Our ref: STH09/01940/28
Contact: Andrew Lissenden 0418 962 703
Your ref: SSD 12469087

3 December 2021

STATE SIGNIFICANT DEVELOPMENT (SSD) 12469087 – THE GUNLAKE QUARRY CONTINUATION PROJECT - PUBLIC EXHIBITION OF ENVIRONMENTAL IMPACT STATEMENT

APPENDIX 3: PRIMARY AND SECONDARY TRANSPORT ROUTE

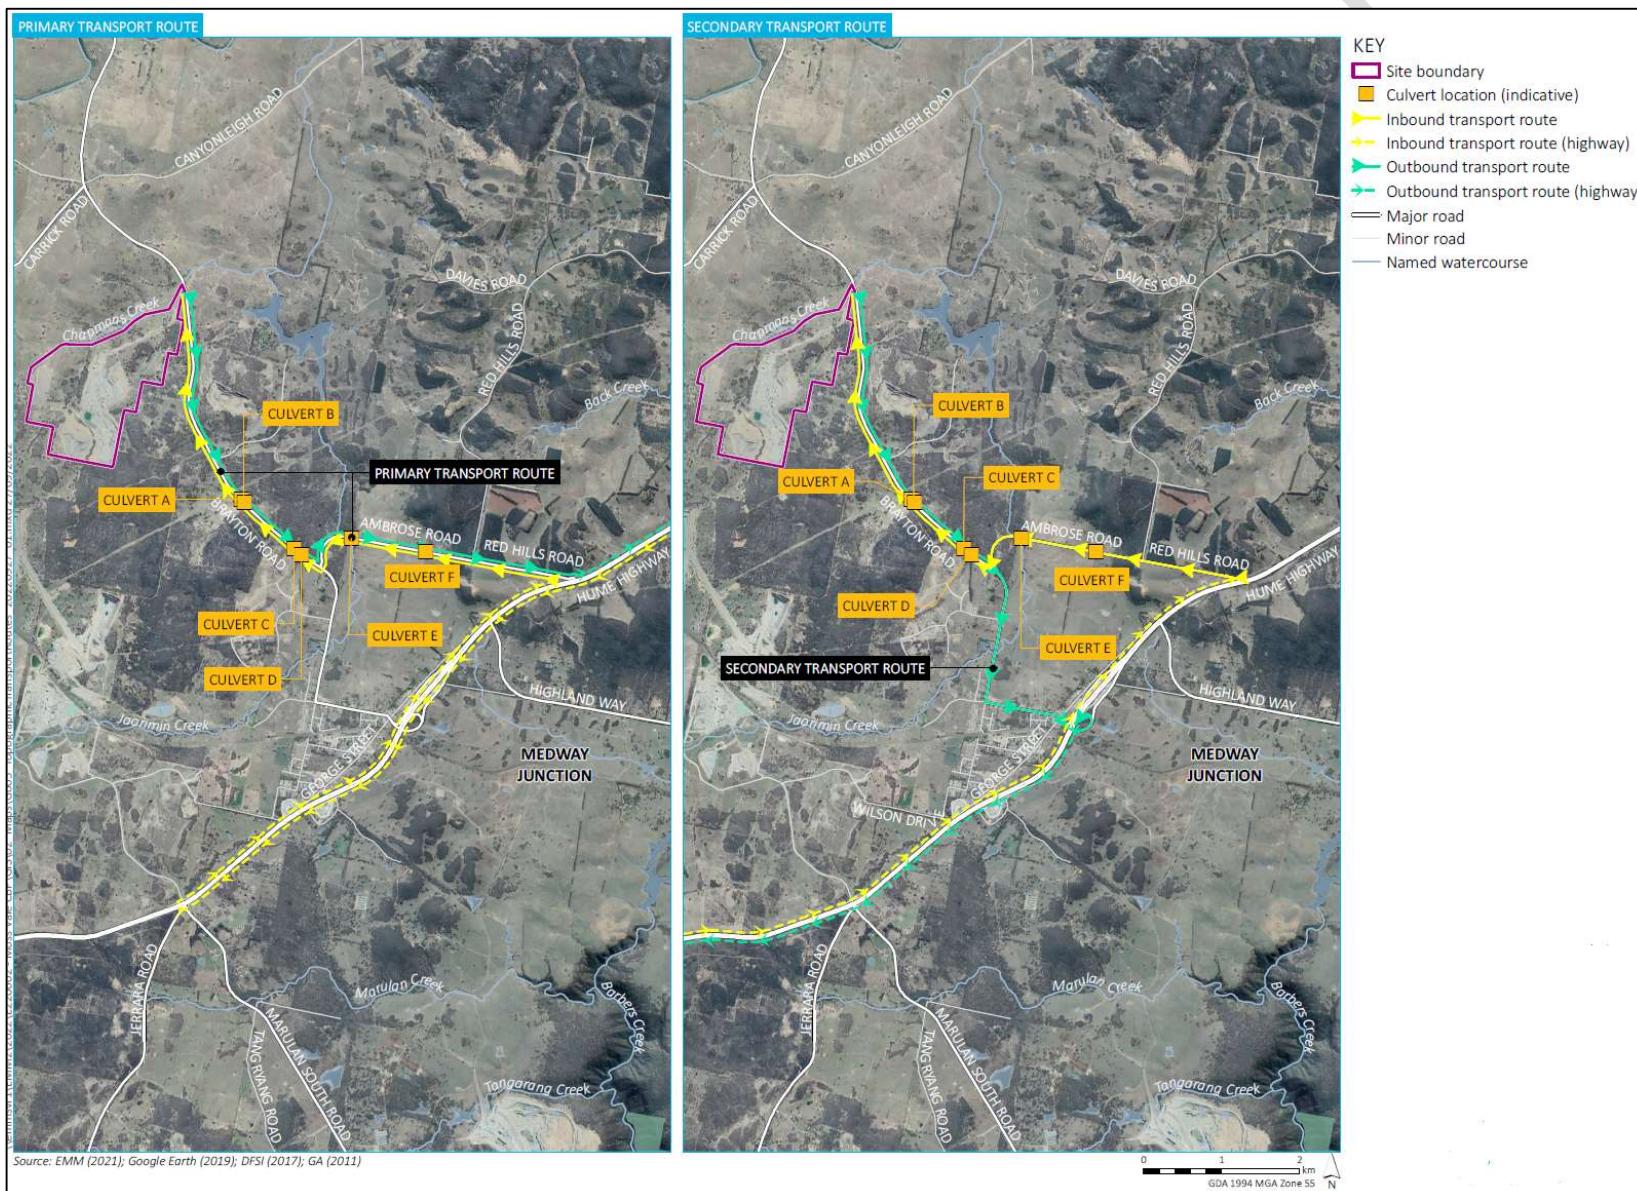
- the SSD application is seeking, in part, to increase the maximum inbound and outbound truck movements via the primary transport route to 375 inbound and 375 outbound movements per day (currently approved at 295 inbound and 295 outbound movements per day) with no more than 4.2 million tonnes per annum of saleable products transported from the site in any calendar year (currently approved at 2.6 million tonnes in any calendar year);
- it has provided Secretaries Environmental Assessment Requirements (SEAR's) (refer to TfNSW letter dated 11 February 2021). A subsequent meeting was had with the operators of the quarry on 19 July 2021 to discuss the TfNSW SEAR's advice; and
- the development will generate additional traffic. The impact of this traffic on the state road network including its connections needs to be considered and adequately mitigated.

- e) An explanation as to why with such a significant increase in truck movements, there is no proposed change to the maximum number of approved truck movements along the Secondary Transport Route.
